Our reference: P-704399-F2T3
Contact: Robert Craig
Telephone: (02) 4732 7593

25 June 2024

Council Response to Request for Advice – Proposed Penrith Stadium Refurbishment at 143 Station Street, Penrith (SSD-68292713)

Figure 16 Trees to be removed and retained

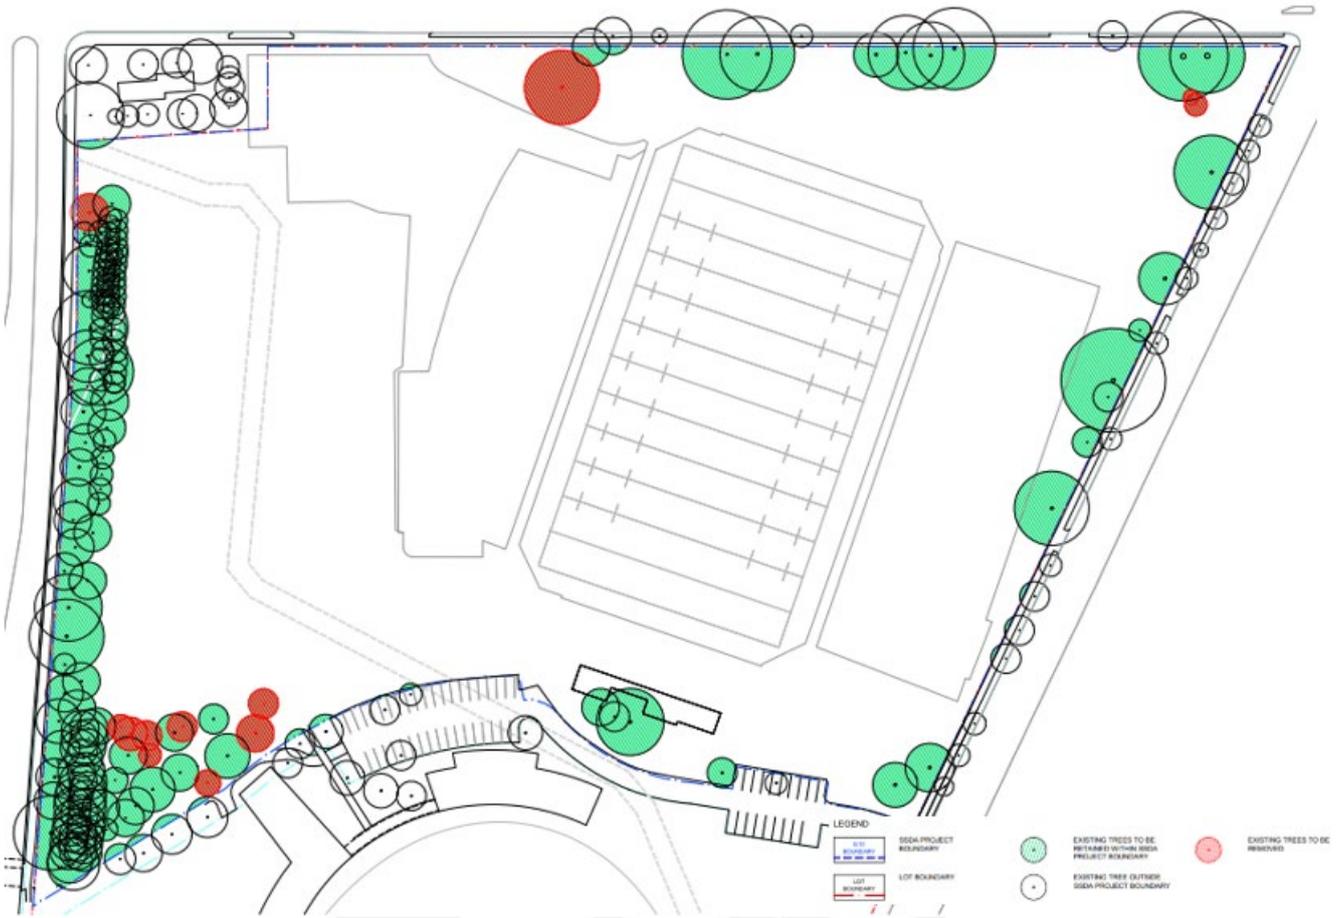
- a) Consideration should be given to retaining all trees south of the existing warm up field. This could be achieved by reconfiguring the car park. In this regard, there is an inconsistency regarding the reasoning for trees to be removed and those to be retained at the southern end of the field where trees are adjacent to each other and impacted by the same work, yet one is proposed to be retained and another removed.
- b) The kiosks on the eastern boundary will have impacts on the already constrained trees in this location. Existing hardstand would

need to be utilised and pedestrian movements directed to avoid impacts to the existing trees. A design that provided these trees with a greater amount of open porous ground would be desirable. Construction on piers as recommended in the Arboricultural Impact Assessment is not supported as even though this is less impactful than constructing on ground, the kiosks will create a rain shadow that will cover the very limited open porous ground already provided.

Figure 47 *Proposed future access arrangements*

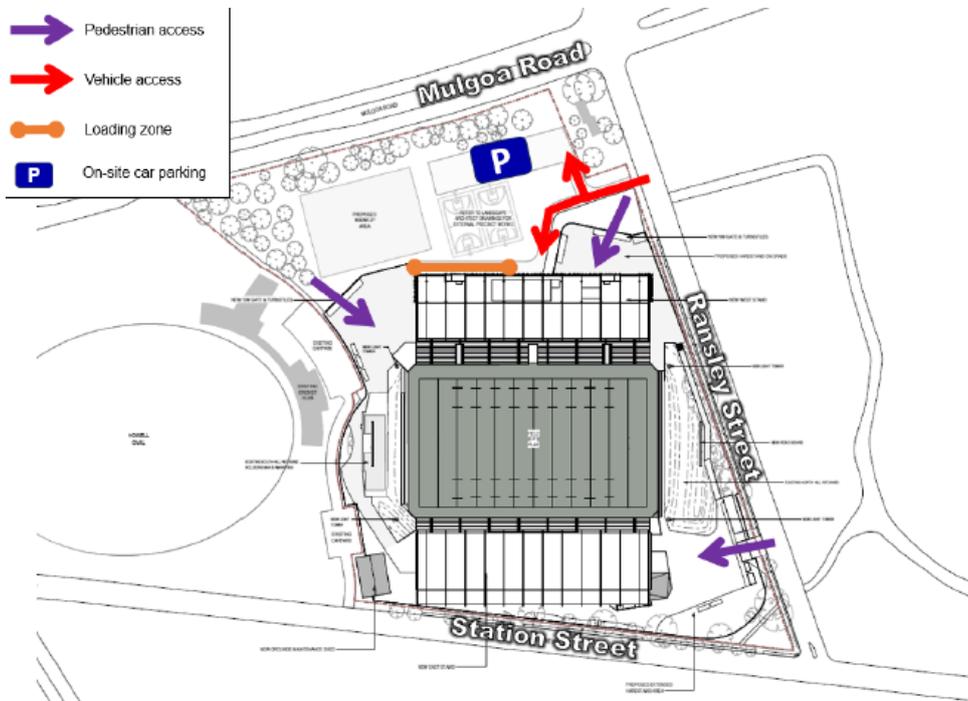
- viii. Details and locations of bus/coach drop-off and pick-up areas.
- ix. Details and locations of taxi/ride share drop-off and pick-up areas.
- x. Turn paths for heavy vehicles in accordance with AS 2890.2 clearly demonstrating satisfactory manoeuvring on-site and forward entry and exit to and from the public road network. Turn paths shall include required clearances and shall not encroach over kerbs or garden beds. The turn paths in the Traffic Impact Assessment only show a 12m Heavy Rigid Vehicle entering the site. The turn paths should show how the vehicle exits the site.
